March 27, 2023 REVISED May 11, 2023
REVISED December 1, 2023
REVISED June 13, 2024

RE: Letter of Intent
Renehan Minor Subdivision
County File No. MS238
5740 Burgess Road

# RENEHAN SUBDIVISION

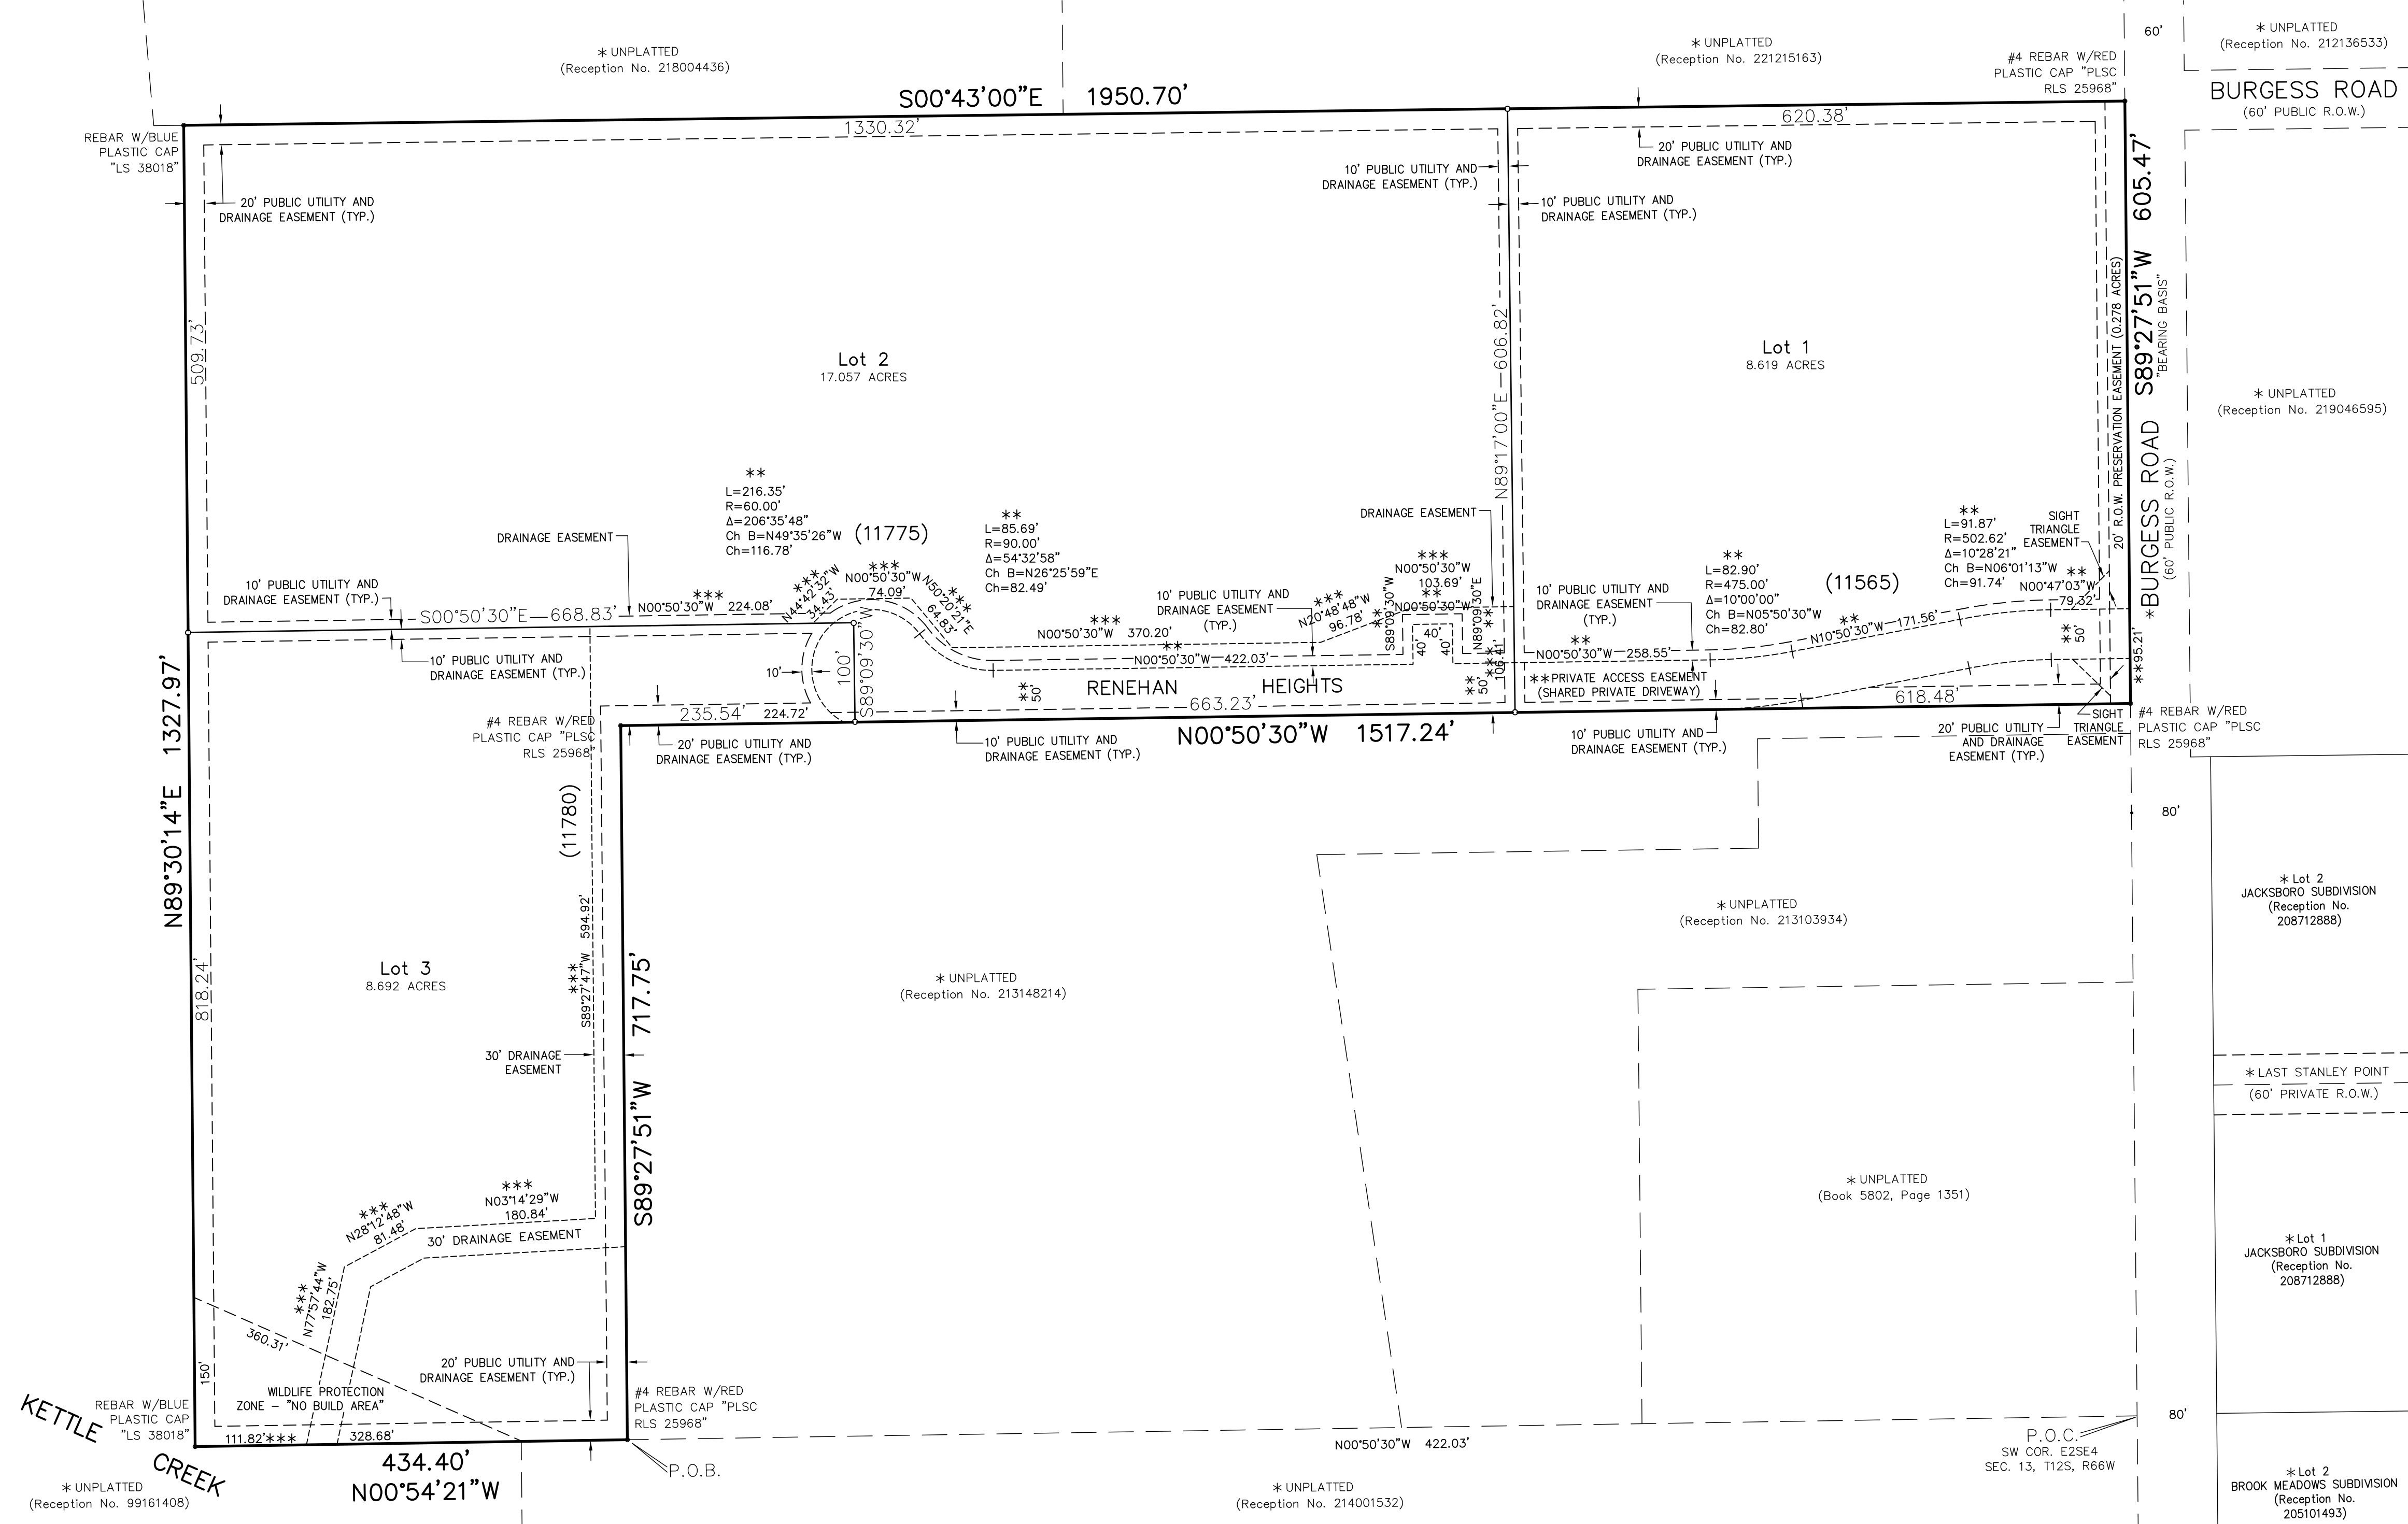
Please address outstanding comments from V2. Please state exactly where the no build restrictions are located (No build area on the southwest corner of lot 3).
